**RE: Sonata Unit 4 Trails Apartments  
Tracts 1, 2, and 3, The Trails Unit 4  
Second DRB Submittal**

RESPEC, agent for Sonata Trails, LLC, owner of the above referenced property, is requesting approval from the Development Review Board (DRB) on this Site Development Plan submitted for your consideration. This is the second submittal to the DRB for this project. The first hearing was held on June 3, 2020. Below is a response to comments received at the first DRB meeting.

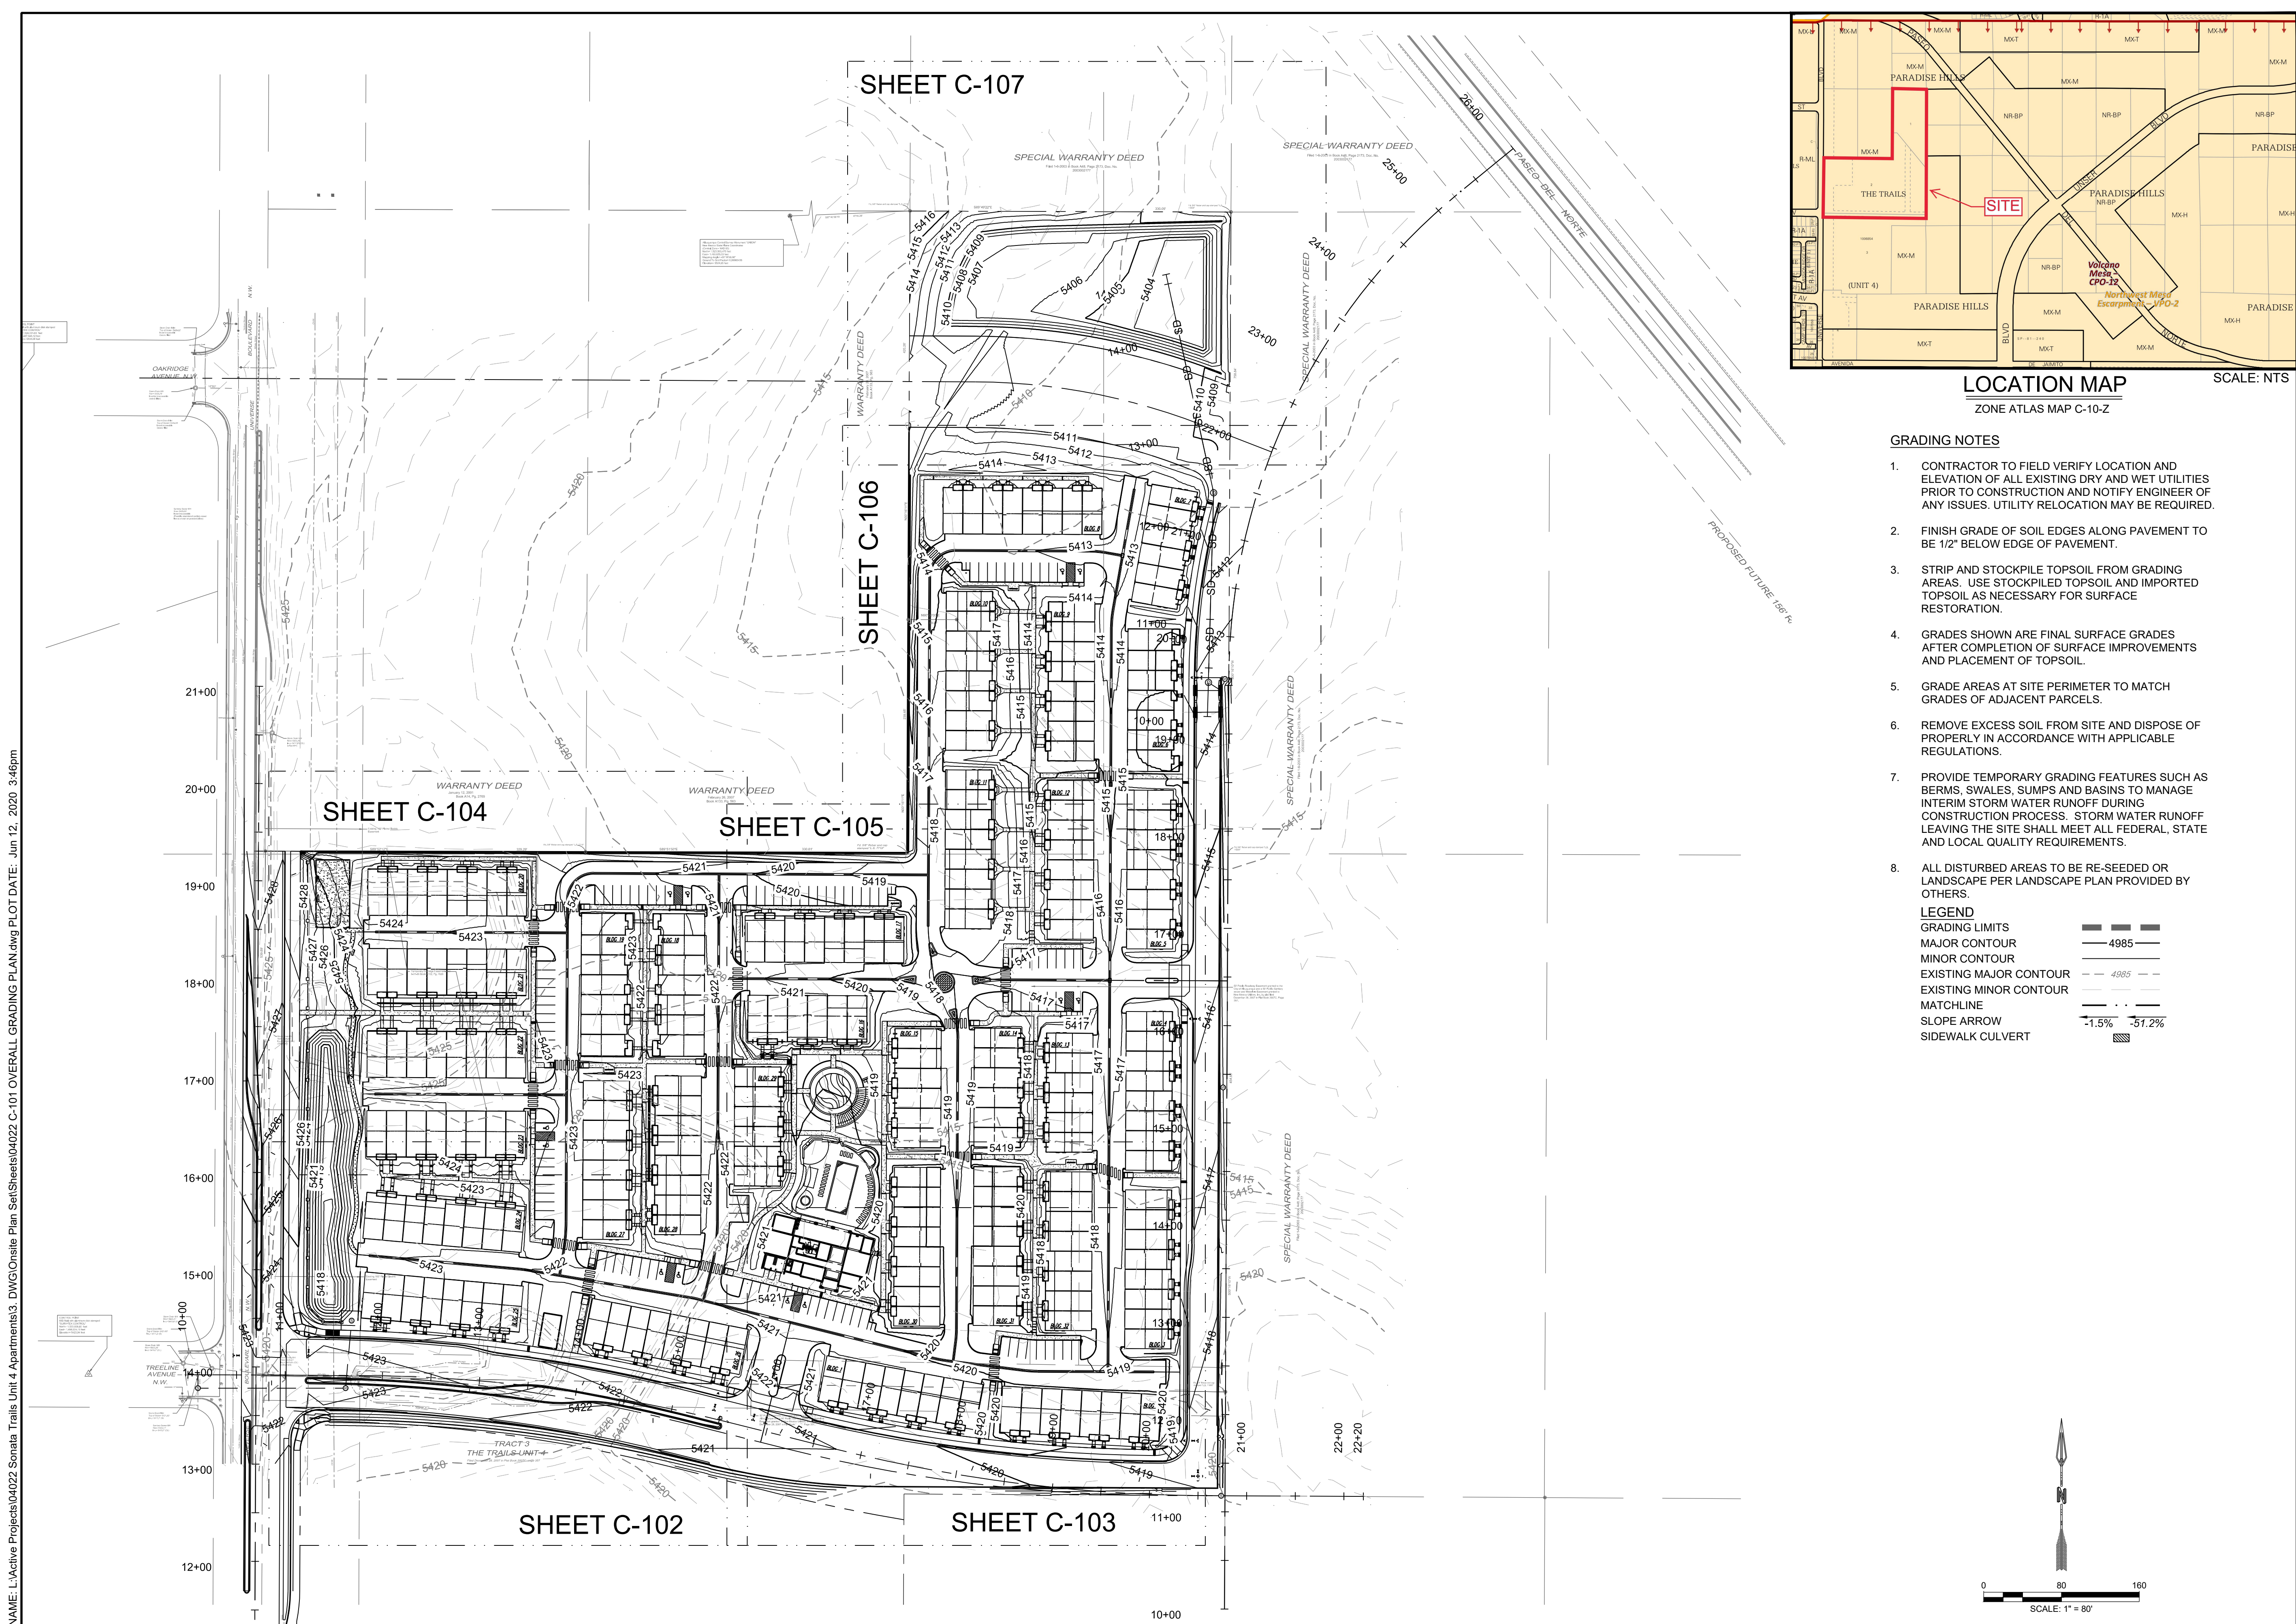
- The Code Enforcement signature line is missing from the Site Plan on Sheet C-100.  
/ Code Enforcement signature line has been added. See revised site plan.
- The Color, Reflectivity, and Roof-Mounted Equipment requirements for the Northwest Mesa Escarpment – VPO-2 must be met as listed below:

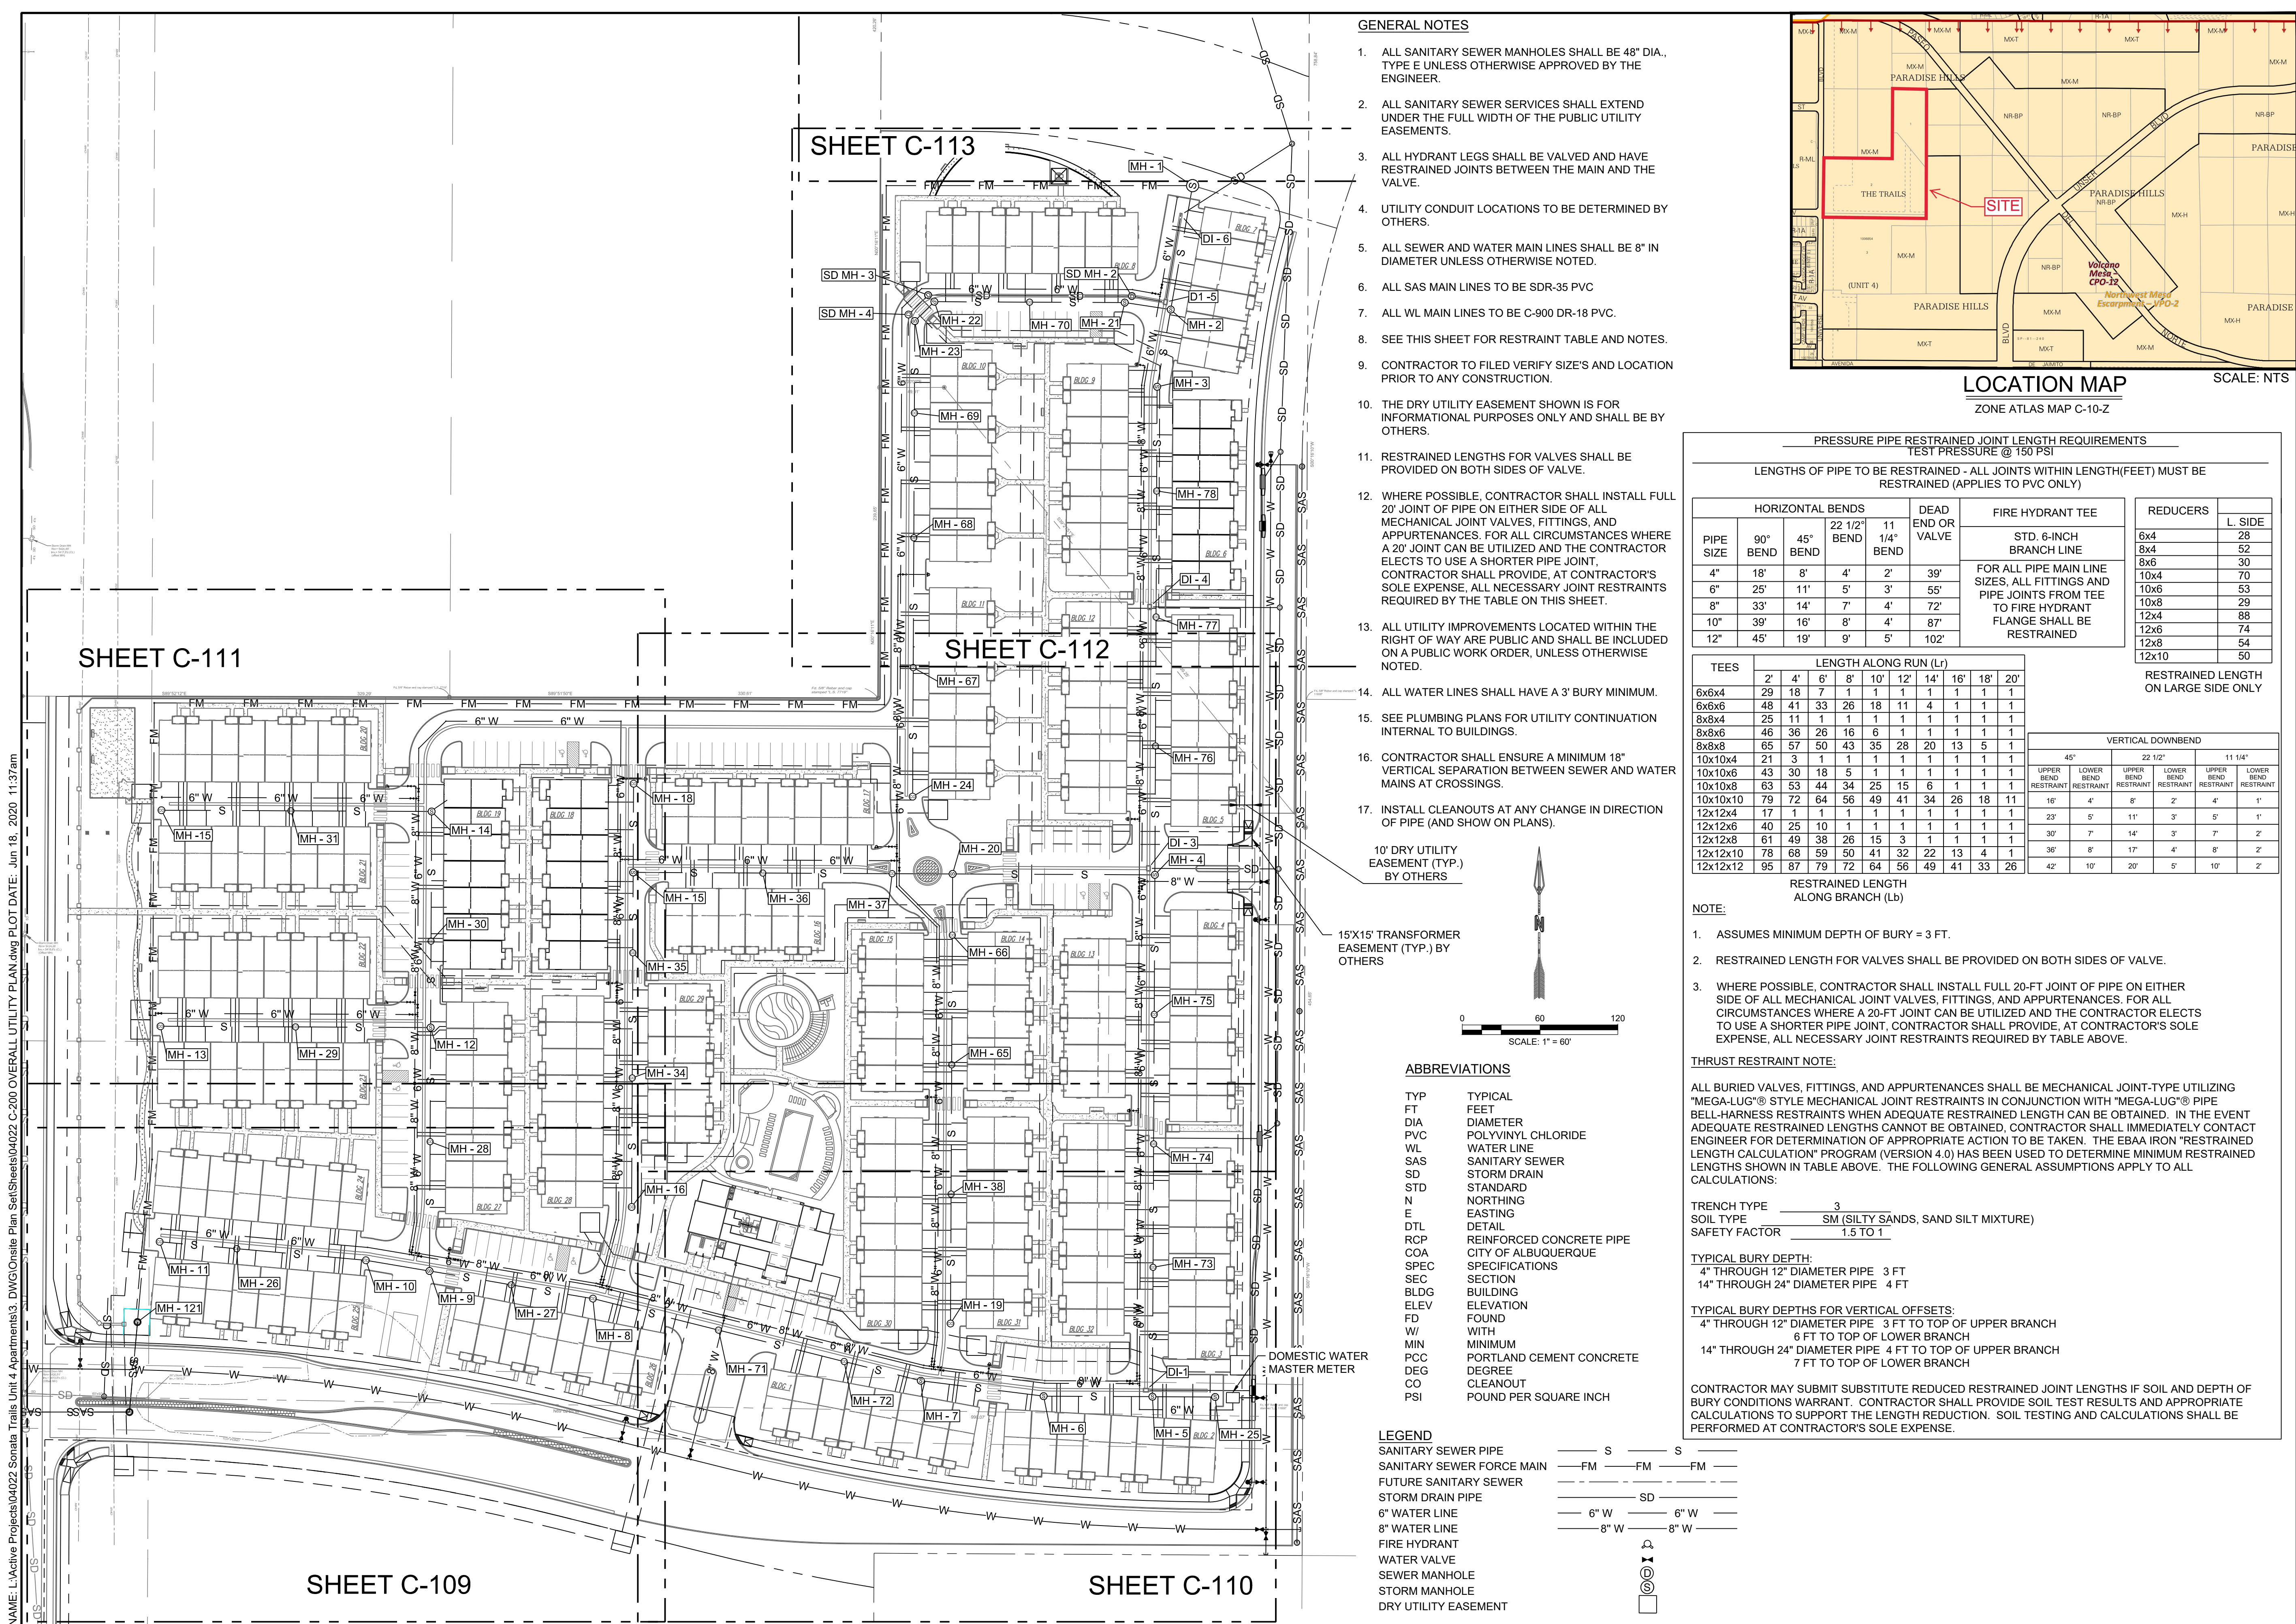
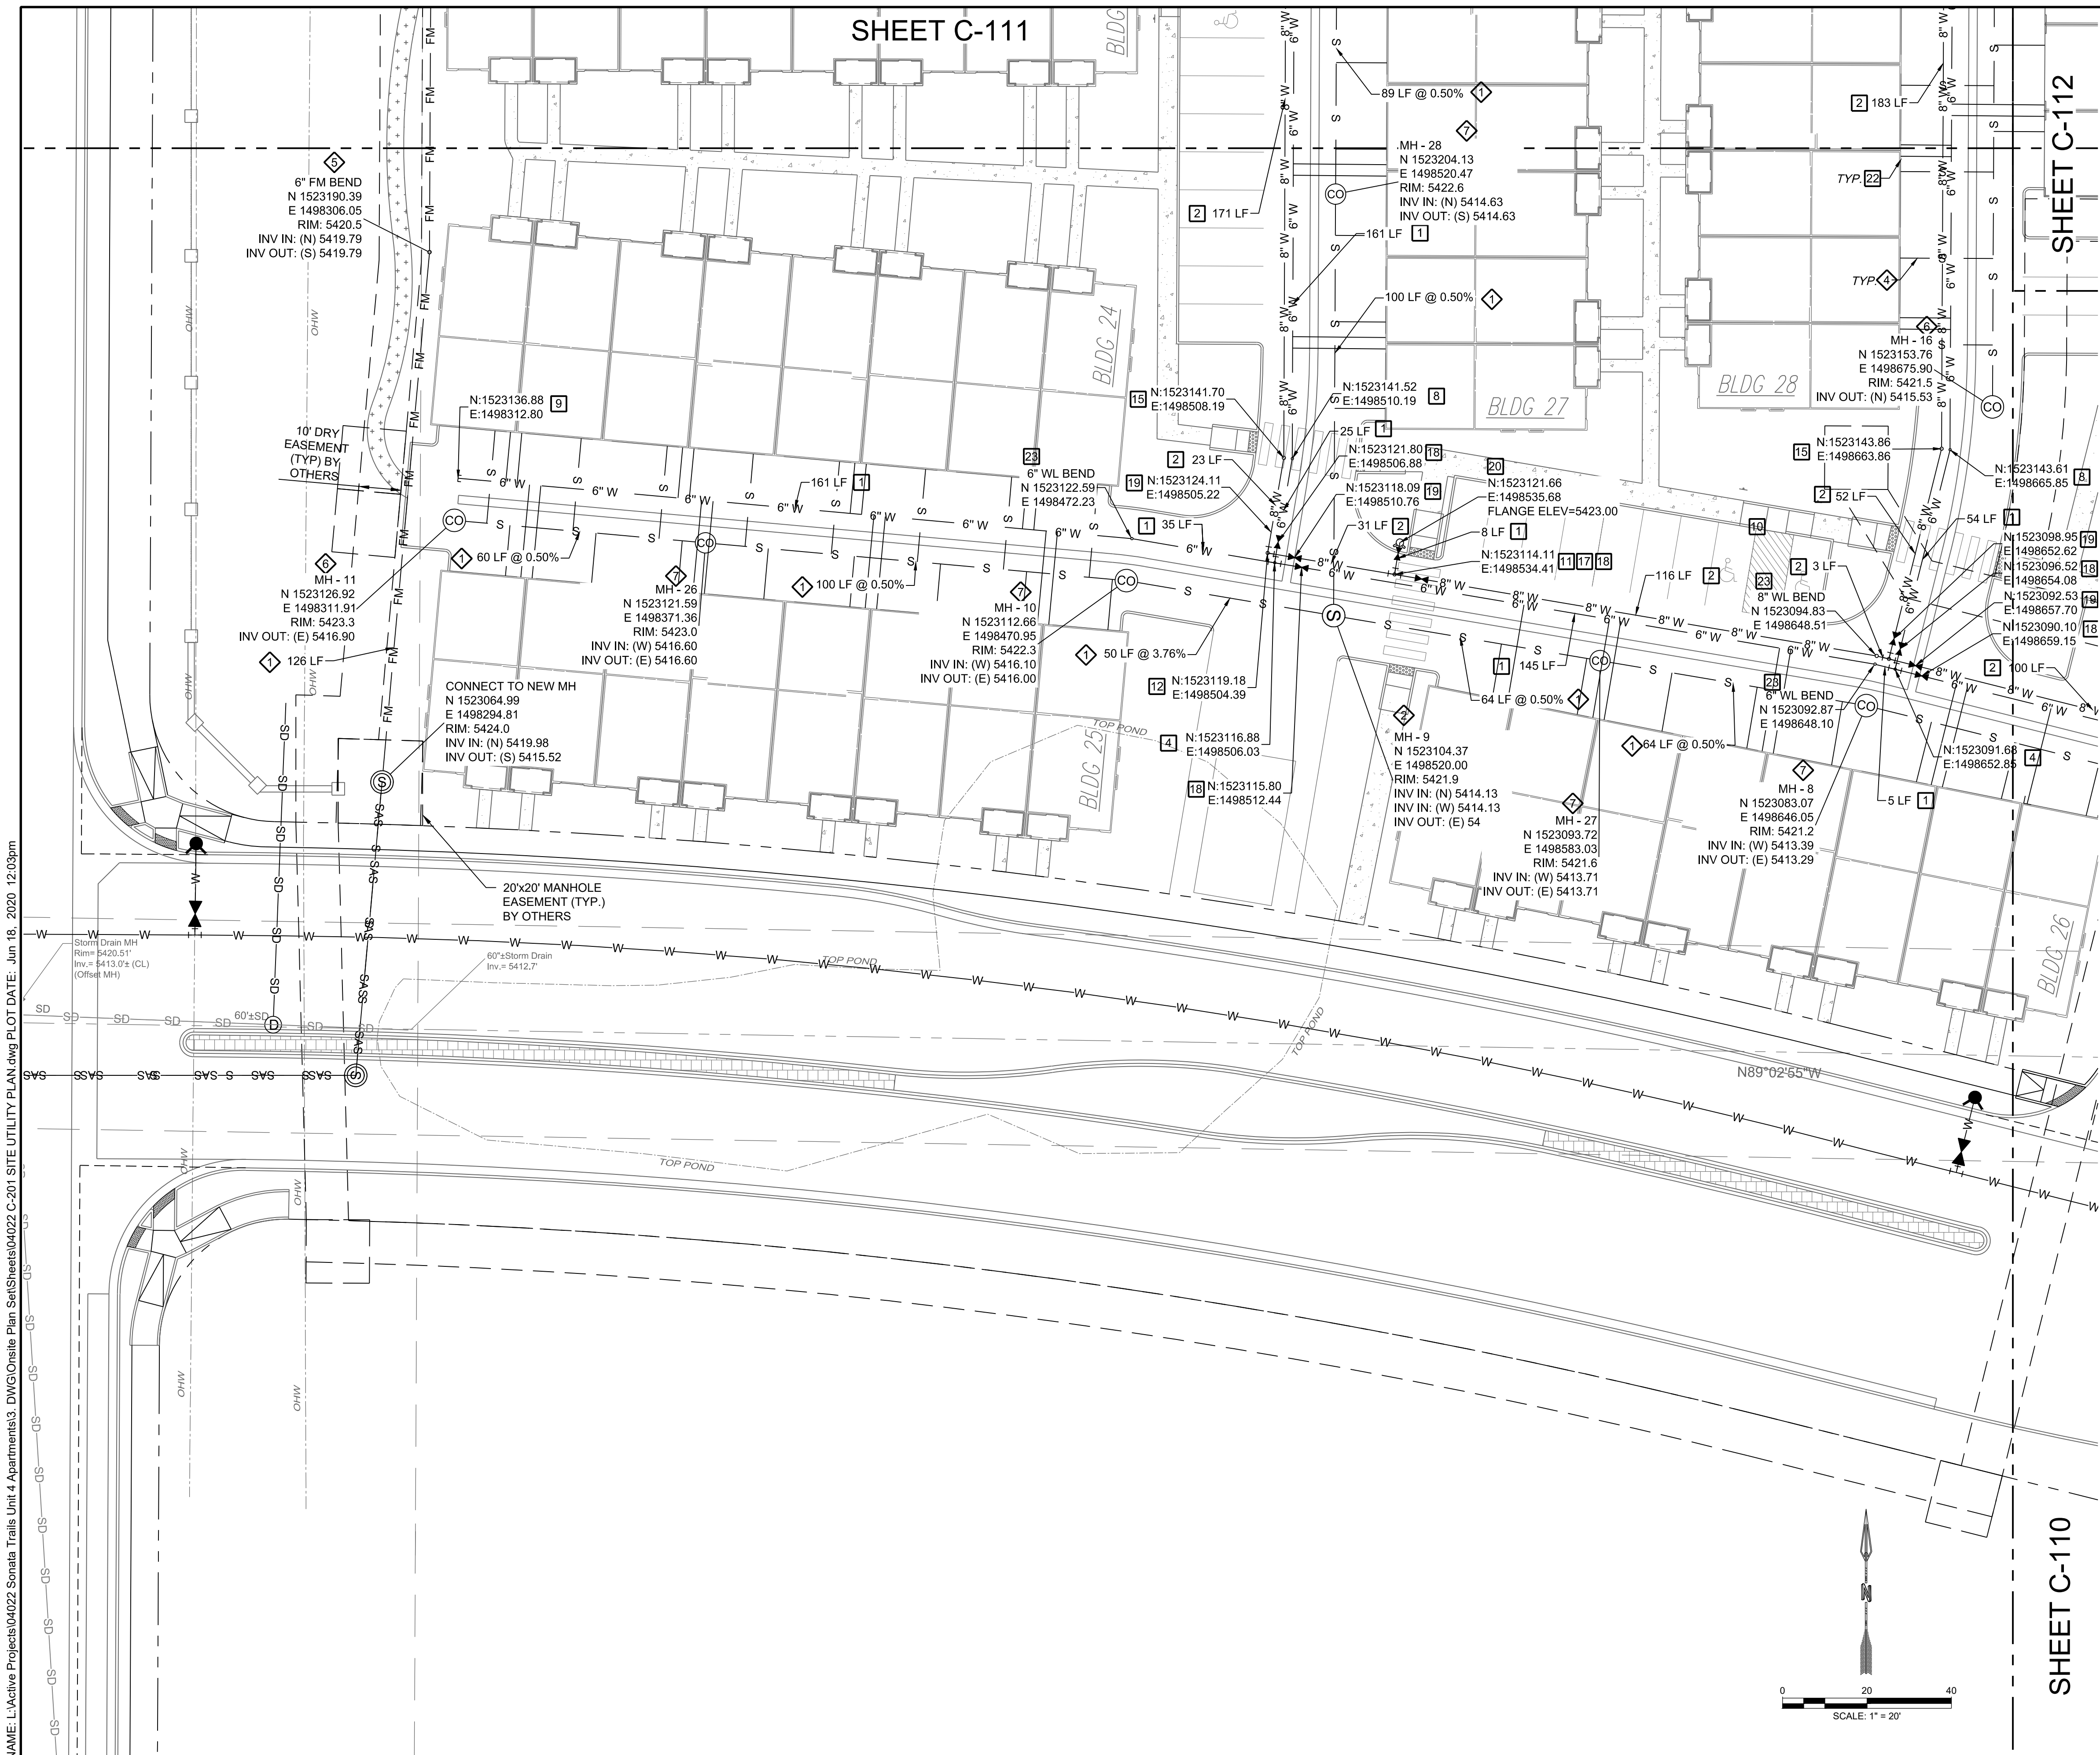
3. Utility Plan
    - a. A meter is shown for each unit. This is not consistent with a previous proposal for a previous request for availability statement which included master meters for the entire development. The proposal for individual meters for each unit (which is not consistent with the calculation for UECs in the Rate Ordinance) appears to be significantly more costly.

- i. The onsite public waterline can be minimized depending on the outcome of metered service locations. The apartment complex can be served by either a master meter or a combination of meters to serve buildings.

- / The meters for each unit have been removed. We are proposing a master meter at the southeast corner of the development. See revised utility sheets.**
